From: Brian Banister [REDACTED]
Sent: 18 May 2022 22:27
To: Planning.Responses <Planning.Responses@arun.gov.uk>
Subject: Re: Planning Consultation on: AB/52/22/PL

Thankyou for the consultation. The comments of the **Arun District Conservation Area Advisory Panel** are as follows:

Application No: AB/52/22/PL
Registered: 10th May 2022
Site Address: 2-4 Arundel Post Office And Delivery Office High Street Arundel BN18 9AA
Grid Reference: 501956 107069
Description of Works: Replacement boiler flue. This application affects the setting of a Listed Building, may affect the character and appearance of the Arundel Conservation area and is in CIL Zone 2 (zero rated) as other development.

Existing stainless steel boiler flue to be removed and replaced.

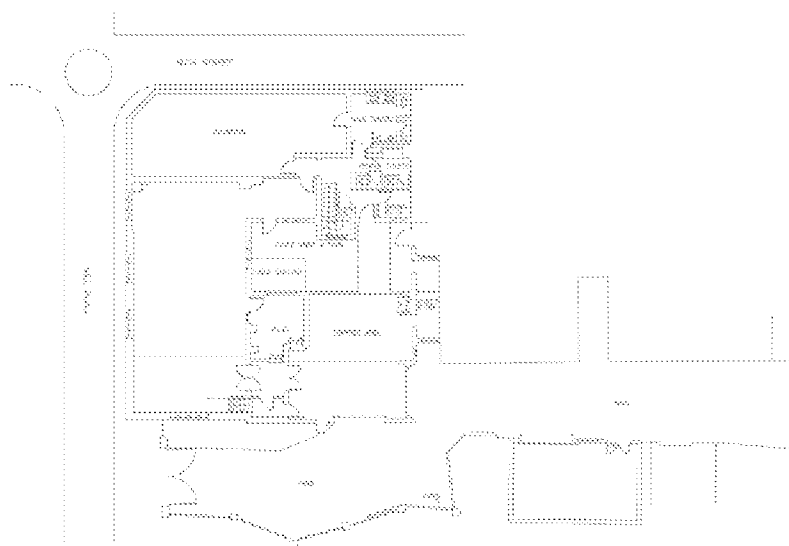
As indicated in the Heritage Statement the replacement flue, although larger and higher than the existing one, will not be seen from street frontages.

However, there is the possibility that it could be viewed from the new open space located on the north side of Mill Road on the site of the former public toilets.

For this reason and also given the designated heritage context and settings it is recommended that the external sections of the new flue should be painted or coated black or dark grey.
